**WELWYN HATFIELD COUNCIL – DEVELOPMENT CONTROL**  
**DELEGATED REPORT**

<b>APPLICATION No:</b>	<b>S6/2009/2677/FP</b>
------------------------	------------------------

The application is for a replacement dwelling.

Existing Ground & First
Floor Plans

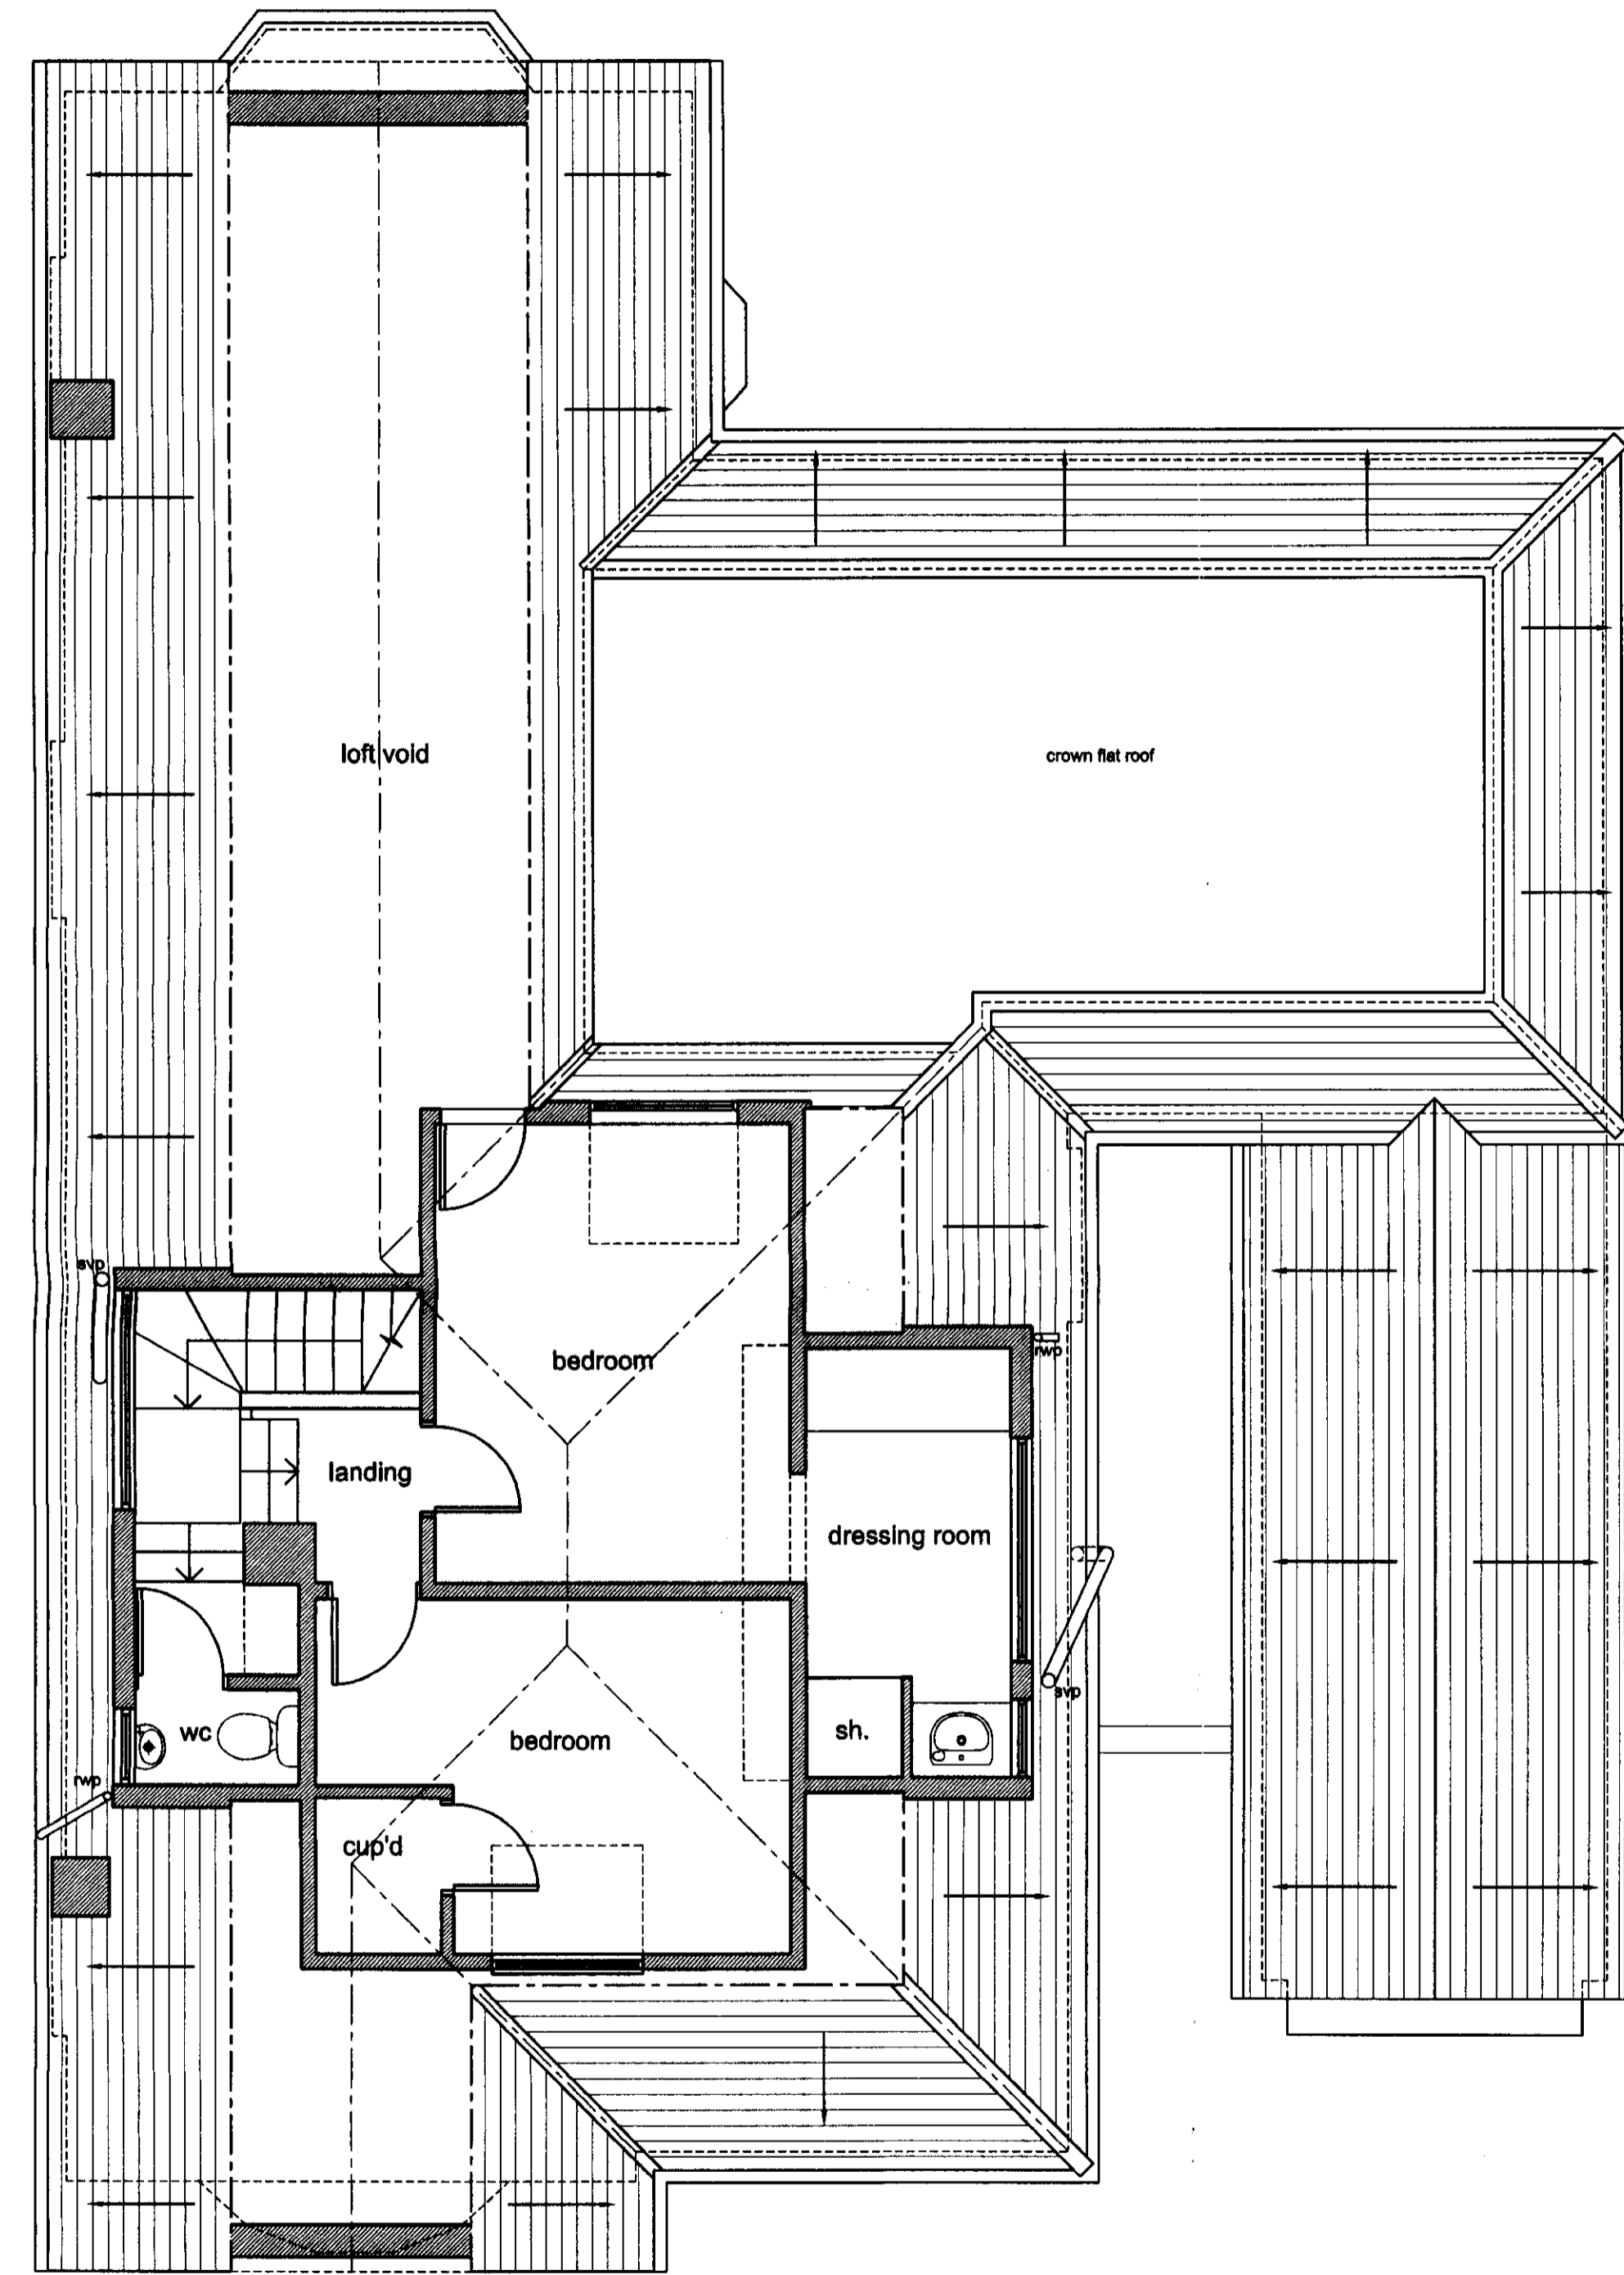
In terms of floorspace comparisons, the LPA's assessment of gross floorspace in regards to the existing dwelling is 221 sqm and the proposed floorspace is 339 sqm.

There is no question that the proposal would far exceed the size of the original building prior to the current extensions, however, even a comparison of the *existing* dwelling compared with that proposed clearly indicates the replacement dwelling is significantly larger in terms of floor area with a 52% increase according to LPA calculations. This is considered to be materially larger than the existing dwelling.

Proposed Ground & First
Floor Plans

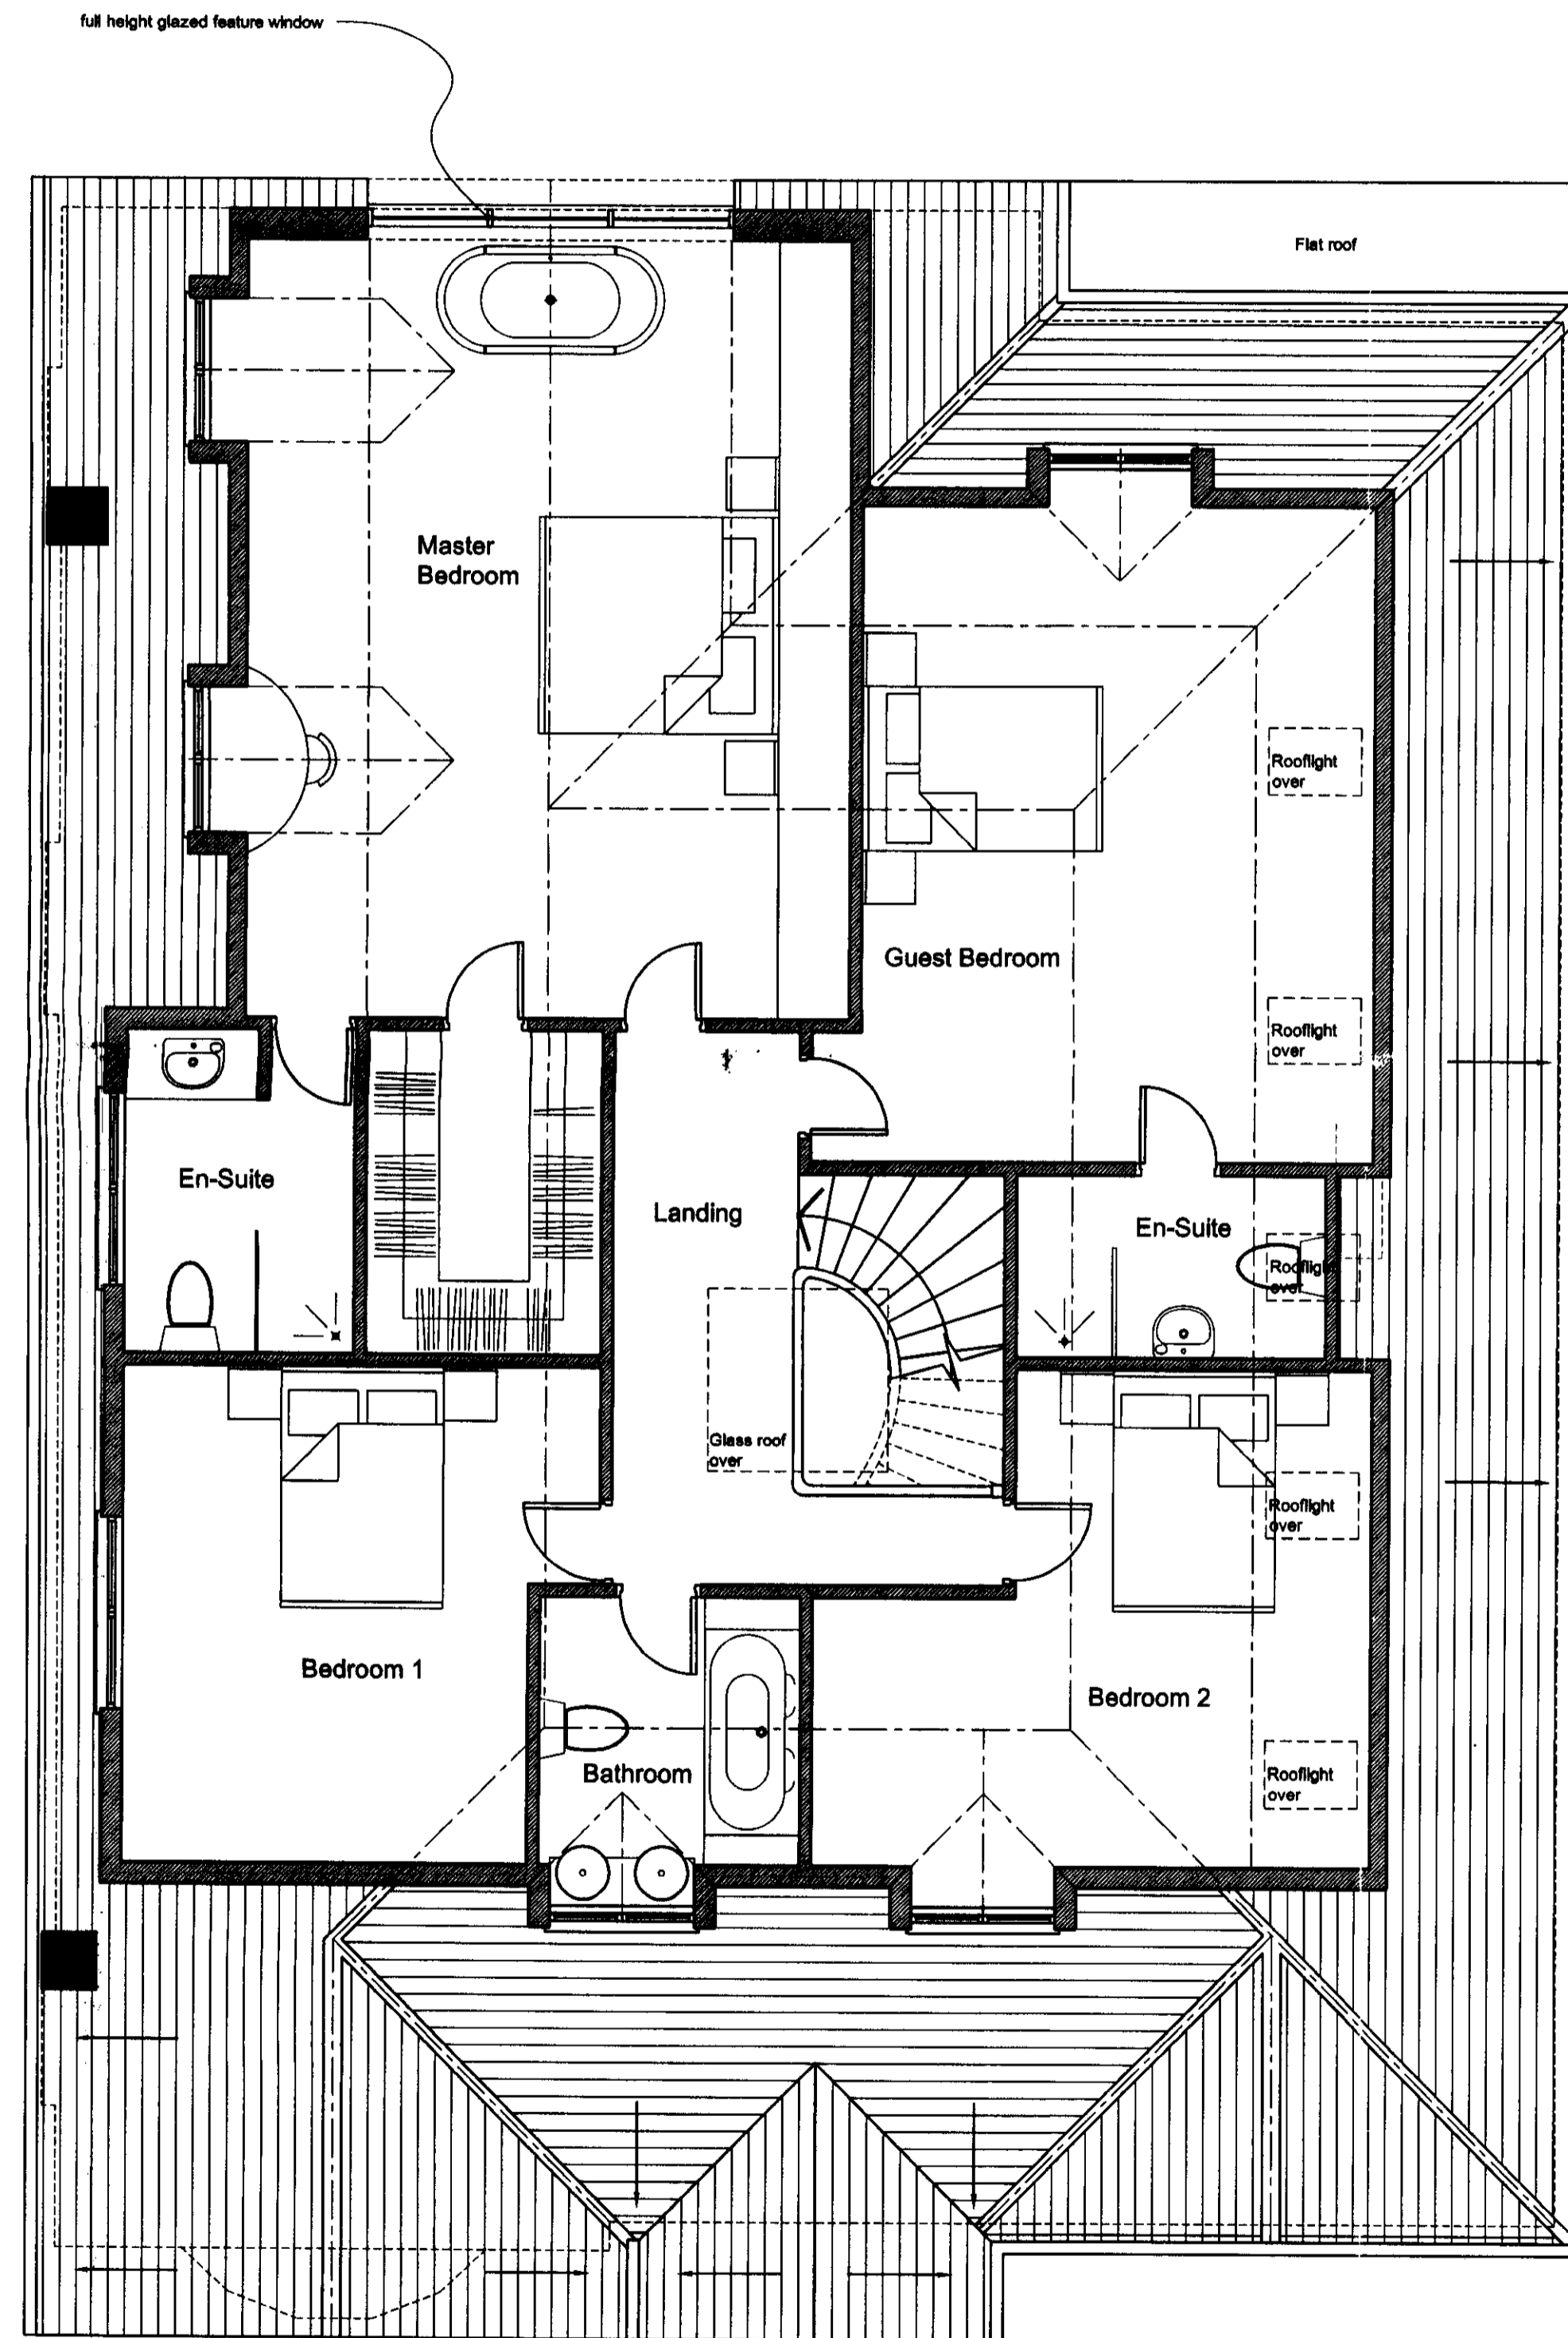
existing dwelling has, for the main part, a low eaves level with dormer style windows at the front and rear, and the new dwelling will still retain this low eaves level with the use of dormers. Although the proposed design has endeavoured to reduce the increase in size by utilising the space in the new roofspace, the resultant increase in bulk, mass and scale is still very significant.

The proposed dwelling, therefore, materially exceeds the size of the existing dwelling house, not only in terms of floorspace but also in terms of its visual impact and, in doing so, is contrary to the requirements stated in the Criteria of Policy RA4 of the Local Plan.

The impact of this on the residential amenity of Nos 65 & 69 is a concern as this terrace and flight of steps would be significantly deeper than the existing terrace.

The rear ground level at No.69 (which forms a terrace around a pool area) would be much lower than the proposed retaining wall and privacy wall above. The impact on this neighbour is considered unacceptable as it would appear overbearing and would result in a loss of sunlight/daylight to this terrace area.

The rear ground level at No.65 is also lower and privacy already is possible a concern as the close boarded fence has already been raised above 2m along this part of the common boundary. The impact of the new deeper rear terrace and privacy wall is also a concern in regards to the impact on this neighbour as it would raise the same concerns as at No.69 with regards to it appearing overbearing and would result in a significant loss of sunlight/daylight to the rear garden area.

It is considered that the proposed rear privacy walls would fail to meet the requirements of the Supplementary Design Guidance in regards to them appearing overbearing to the adjoining neighbours and would also result in a significant loss of sunlight/daylight to their gardens.

- 1. The site lies within the Metropolitan Green Belt where there is a presumption against inappropriate development. The proposed replacement dwelling would materially exceed the size of the original dwelling being replaced as it would be significantly bulkier due to the increase in floorspace and volume. It would also appear a more conspicuous structure and, as a consequence, it would also be more visually intrusive in the countryside to the detriment of the openness, character, appearance and visual amenity of the Green Belt. As such, the proposed development represents inappropriate development and no very special circumstances are apparent in this case to set aside Green Belt policies of restraint, and so is contrary to the advice contained in Planning Policy Guidance Note 2 and would conflict with Policy RA4 of the Welwyn Hatfield District Plan 2005.

- 2. The proposed rear side retaining and privacy walls to the new rear terrace and steps would appear overbearing and so harmful to the residential amenity of the adjoining neighbours at Nos.65 & 69 The Ridgeway due to their excessive height and close proximity to these adjoining properties rear private amenity space. Furthermore, the height of these walls would also significantly impact on the sunlight and daylight to these adjoining rear gardens. The proposal is therefore contrary to Policy D1 of the Welwyn Hatfield District Plan 2005 and the accompanying Supplementary Design Guidance and Planning Policy Statement 1 (Sustainable Development).
